Project: Great Wolf Lodge, Chesterton  
Prepared by: Kathryn Lewis  
Approved by: David Lewis  
Date: 7<sup>th</sup> February 2020

- 1.3 Following submission of the planning application comments have been provided by the Bicester Delivery Team (BDT) at CDC in respect of the submitted planning application. This Technical Note has been prepared in response to the comments from the BDT and provides further details in relation to walking and cycling connectivity, shuttle bus provision and car parking provision.

Drawing:  
1803047-03

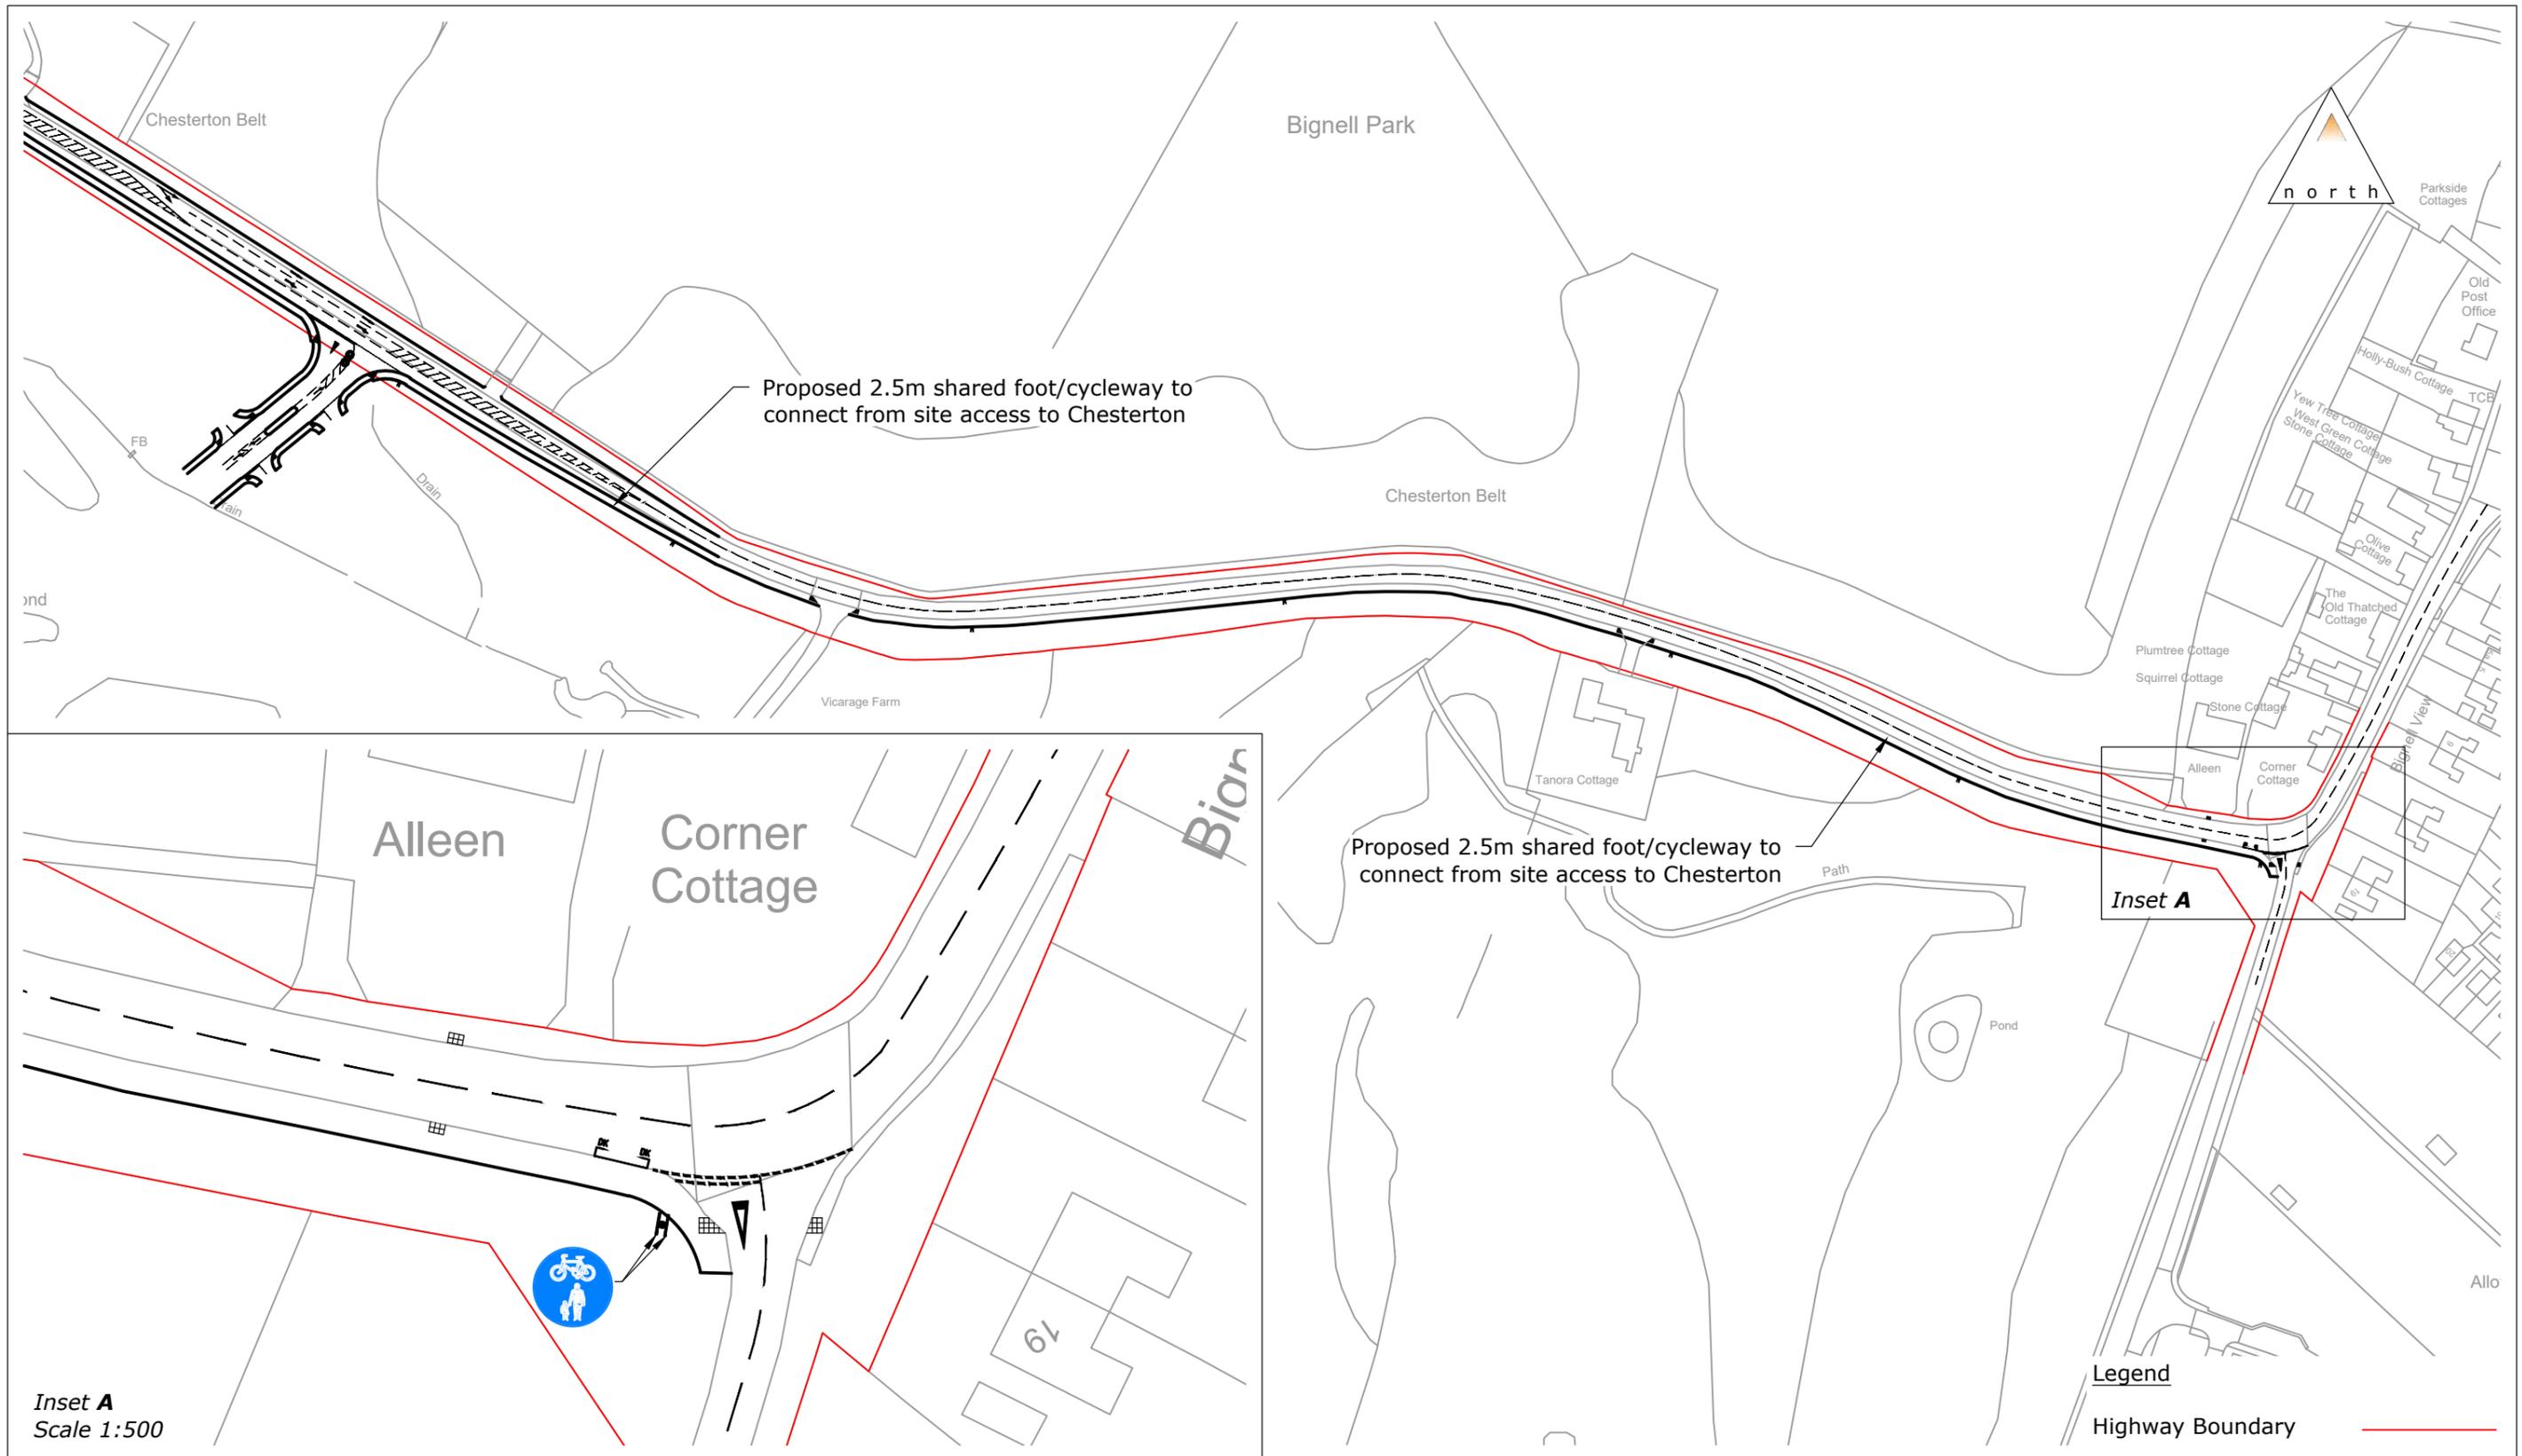
- 2.1 Following further discussions with OCC, the proposed footway west of the site access is to be extended west to connect with Public Right of Way (PRoW) 161/11 to the west of the M40 overbridge. This provides a betterment to the existing connection between PRoW 161/06 and PRoW 161/11 providing pedestrians with a footway, where they are currently required to walk within the grass verge to connect between PRoW 161/06 and PRoW 161/11. The proposed extended footway is shown on Drawing 1803047-03, attached at [Appendix A](#).

Drawing:  
1803047-02

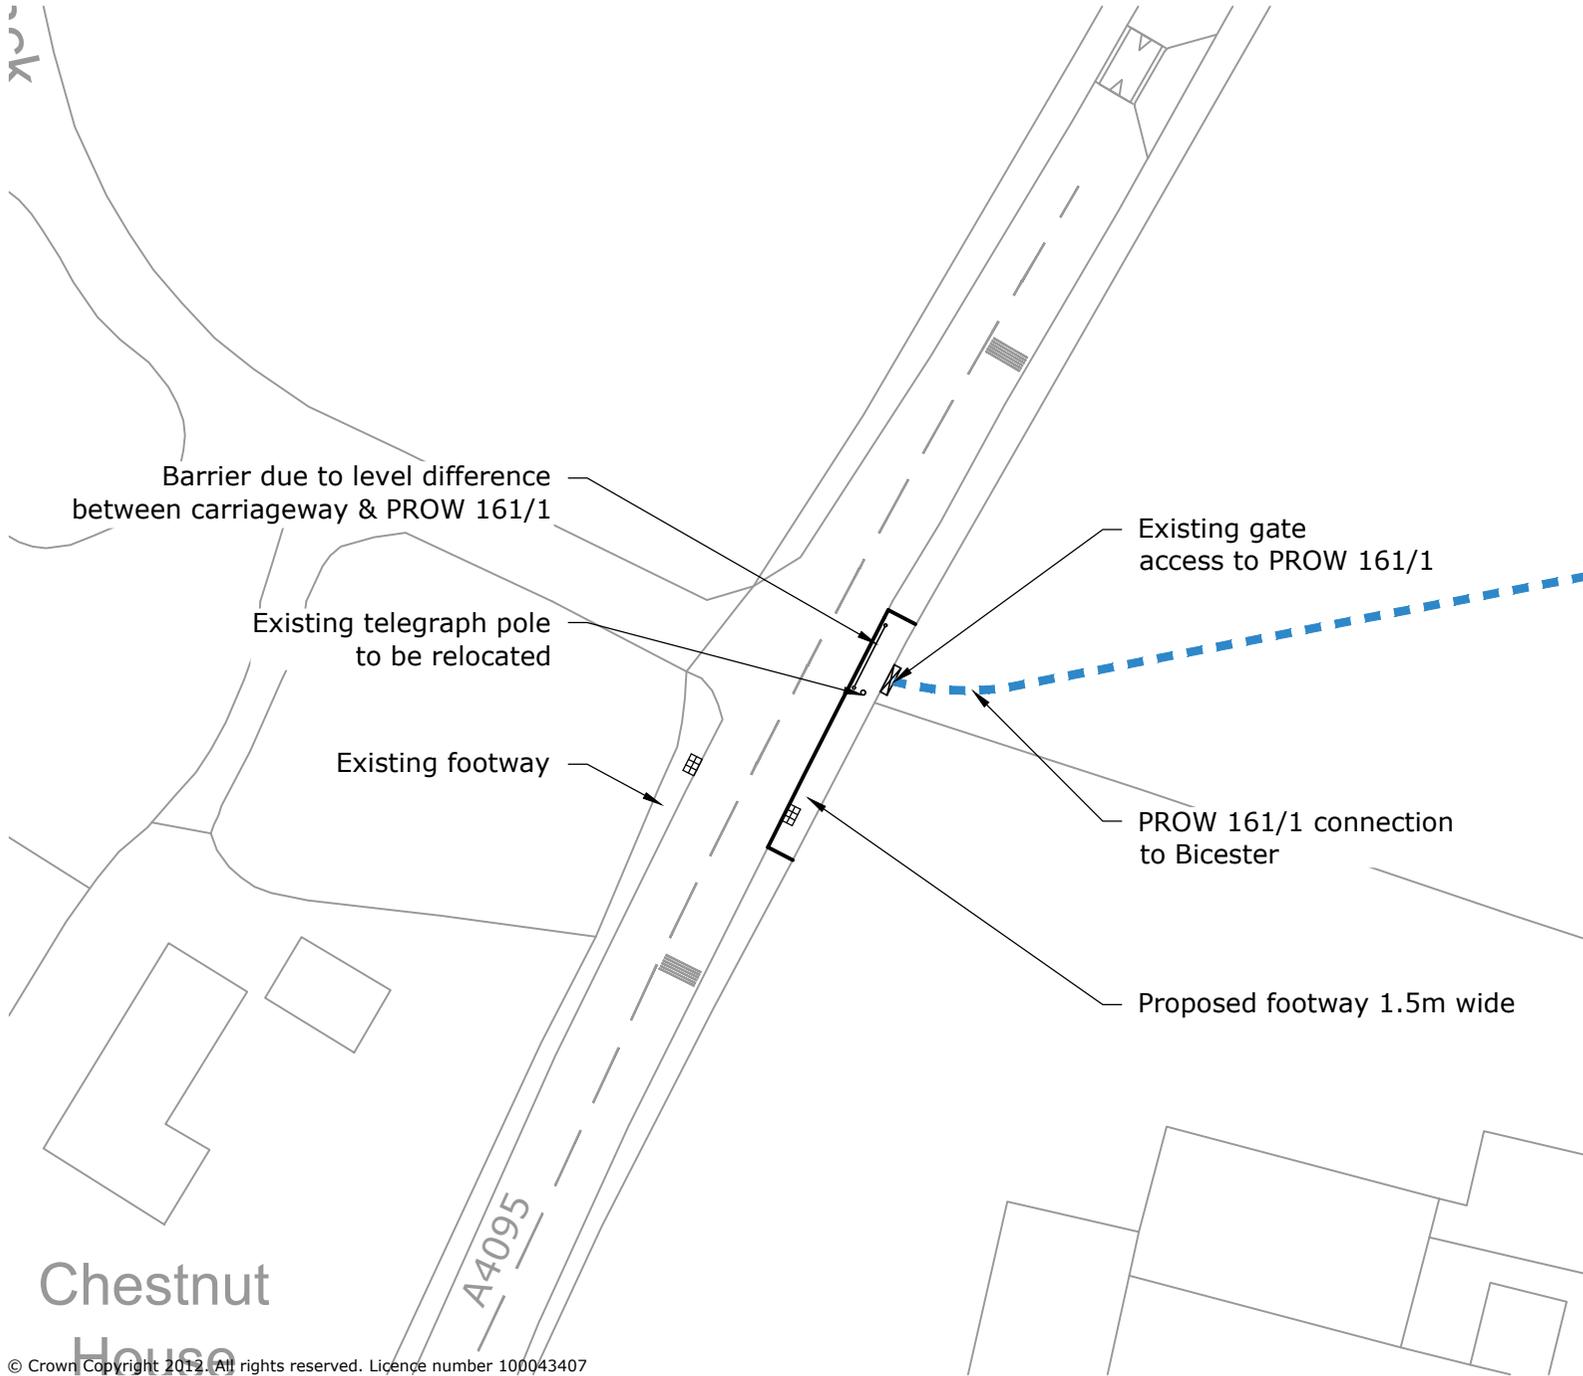
- 2.3 The design and width of the proposed shared foot/cycleway from the site to Chesterton, along the southern side of the A4195 accords with the Oxfordshire County Council “Cycling Design Standards” (Summer 2017) and has been agreed with Officers at OCC.
